13 February 2020

**DCO Application for the Southampton to London Pipeline Project
SDNPA Deadline 5 Submission**

I write to provide this Authority's response at deadline 5 to:

SAMPLE VEGETATION RETENTION AND REMOVAL PLANS SHEET 18 (BASED ON INDICATIVE PIPELINE LOCATION)

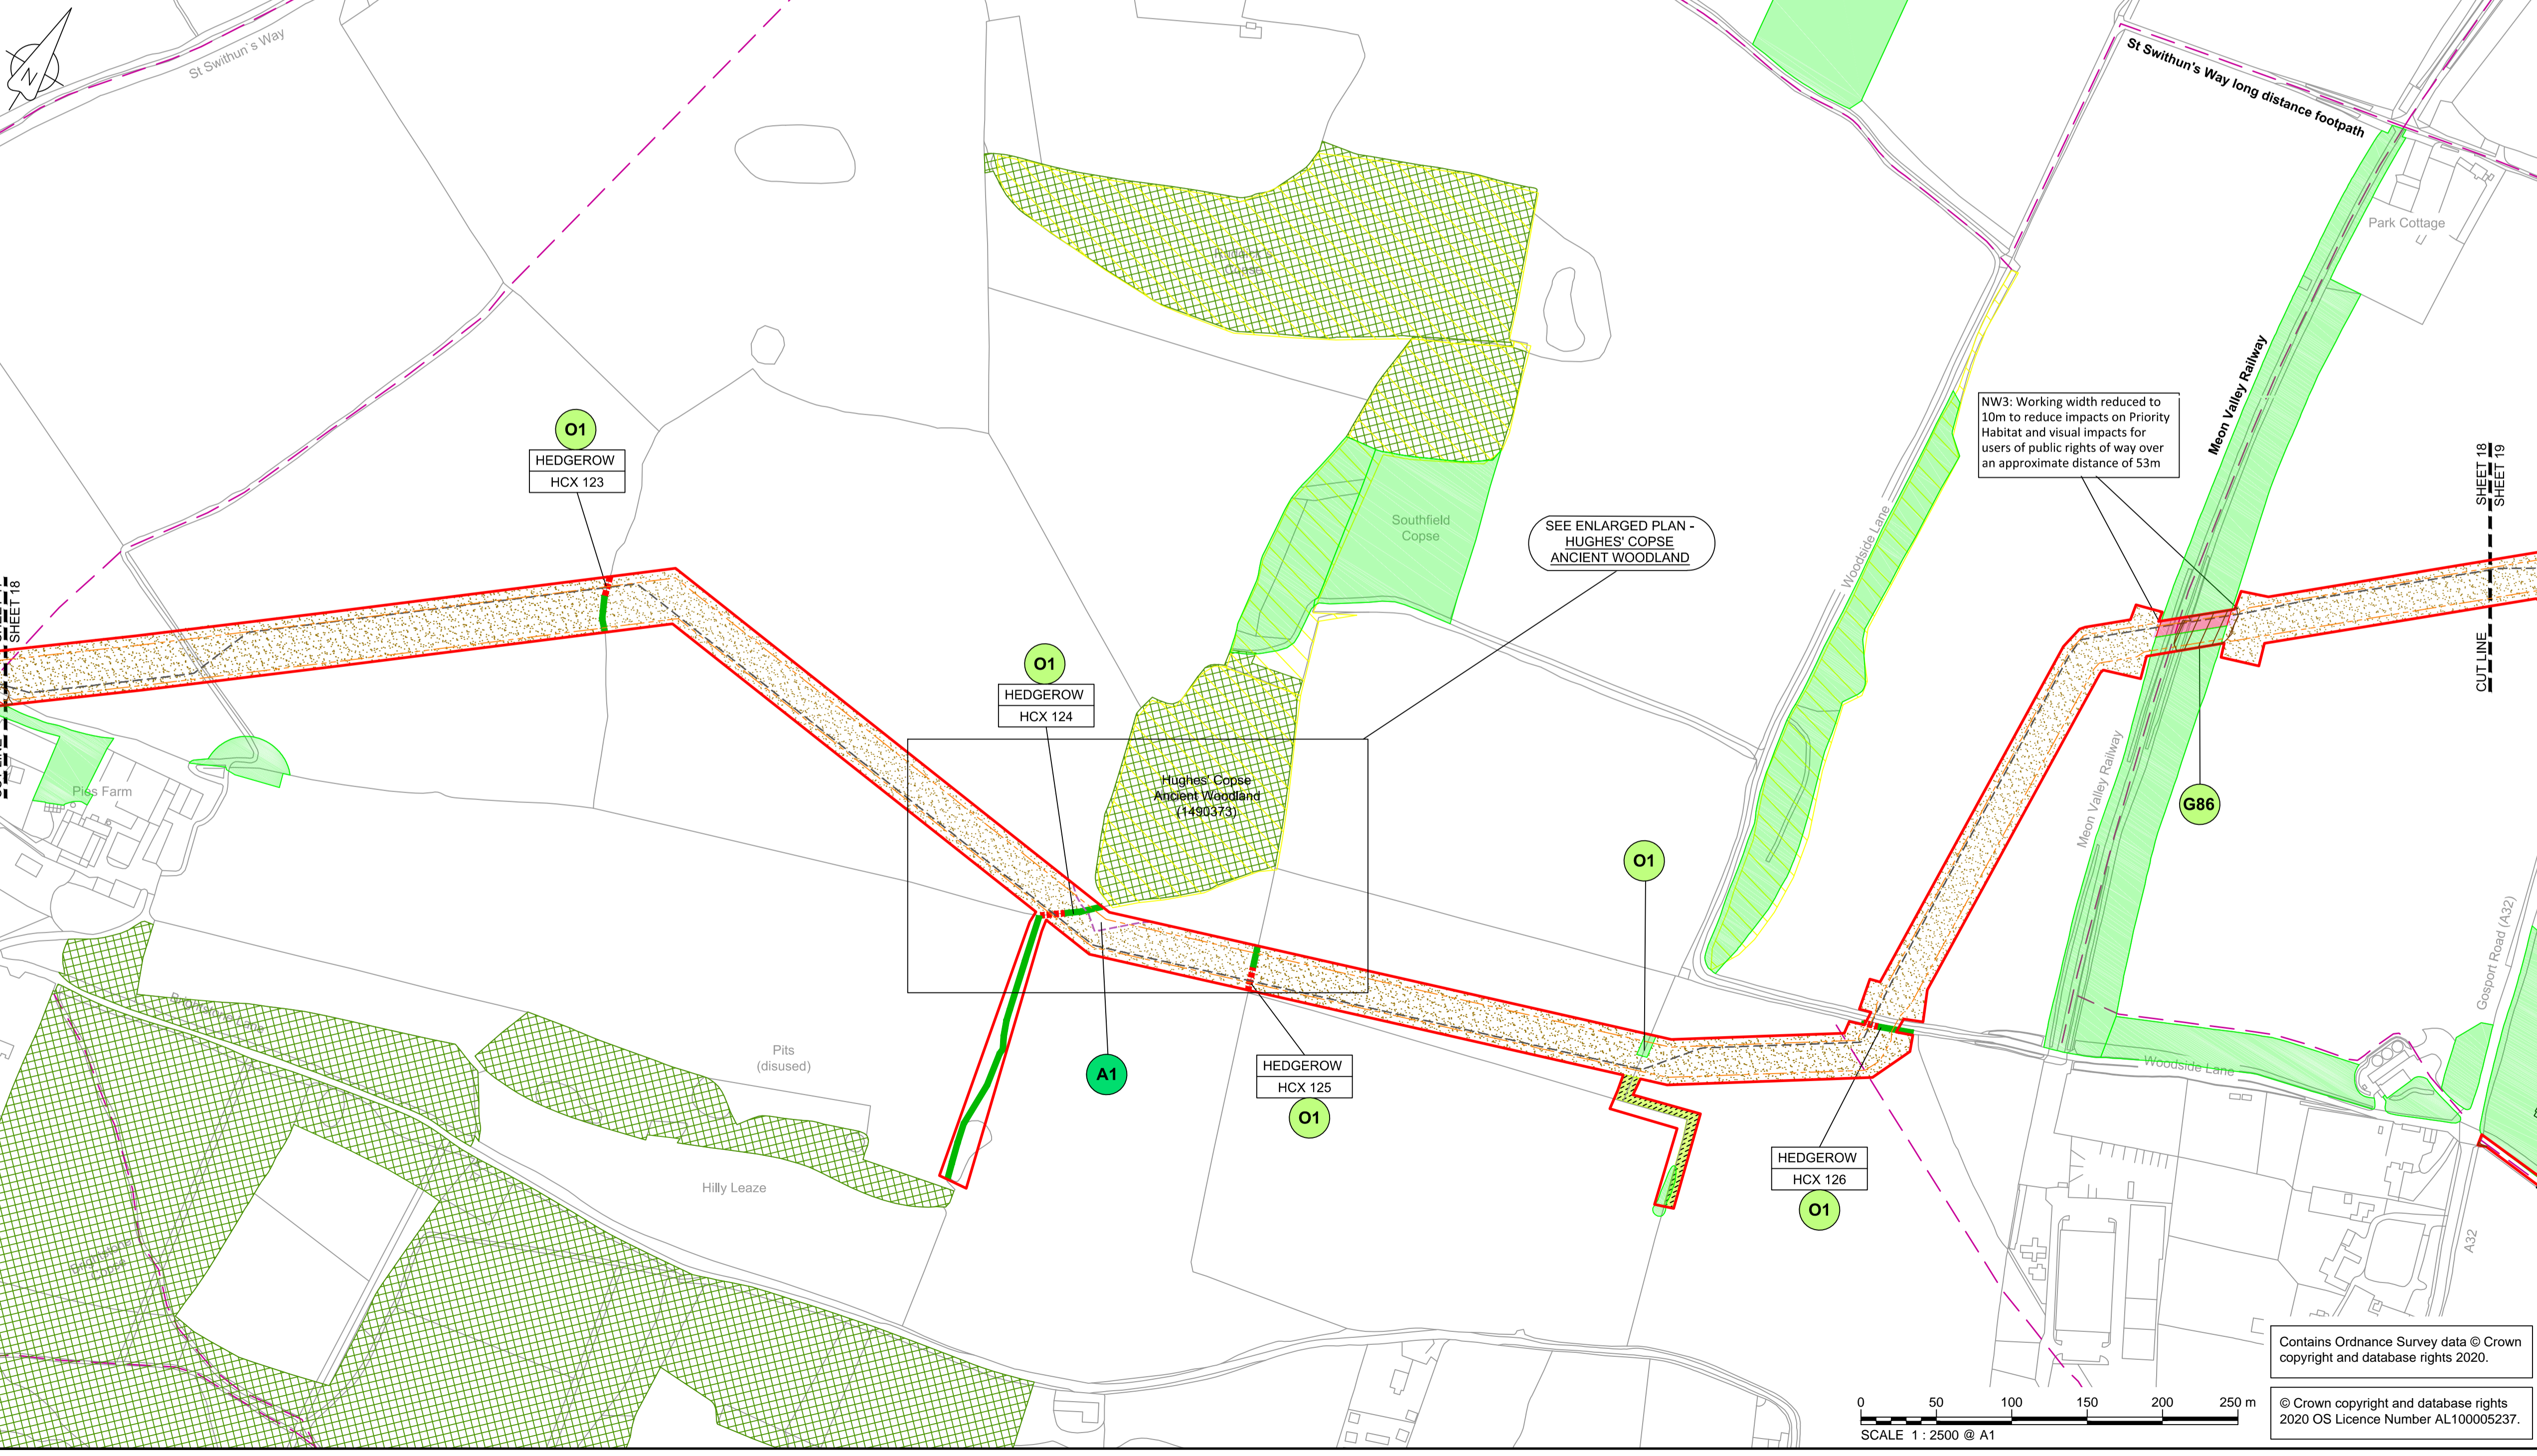
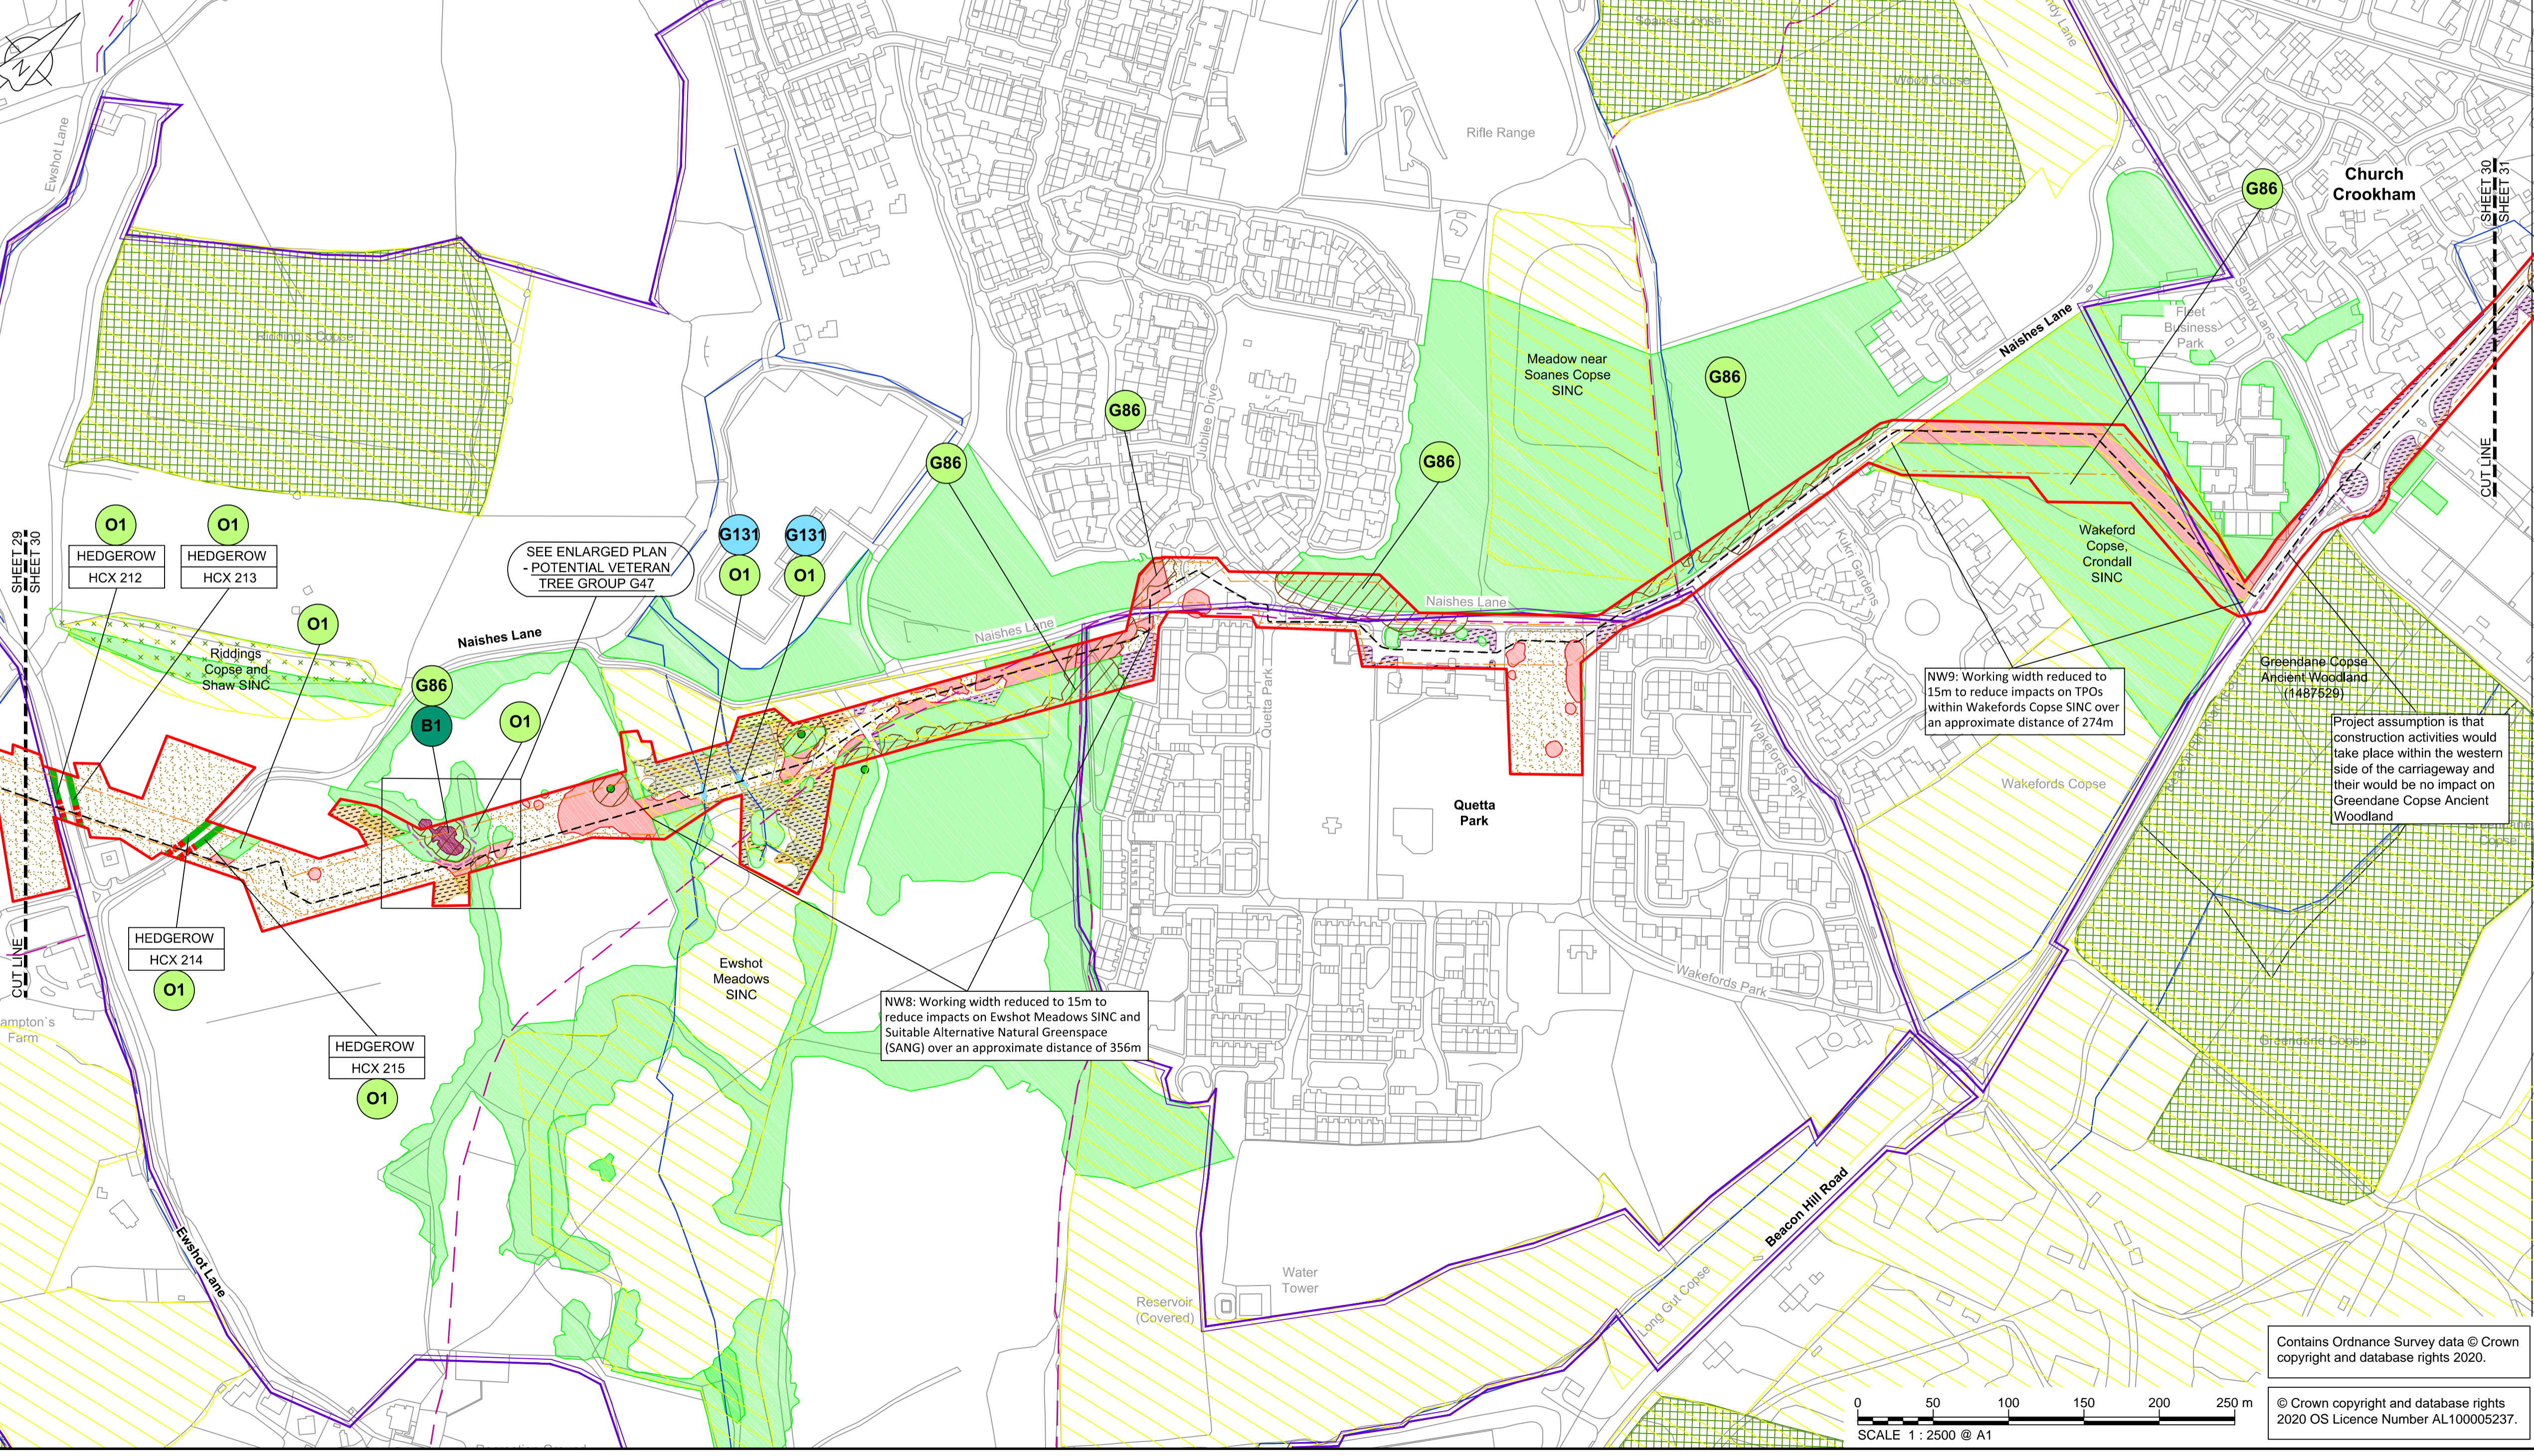
- a. An Arboricultural Management Plan is not included.
 - b. For the vegetation retention and removal drawings no new information has been included, nor has it been committed to be included in the future. Information on these drawings is based on the existing, incomplete baseline (where only trees above 300mm in diameter have been surveyed) and on which SDNPA has previously raised an issue. The SDNPA also consider that the drawings should include arable/pasture field cover and arboricultural protection measures. The vegetation retention and
-

removal drawings give no record of tree works to trees to be retained and, in our view, they should show this information.
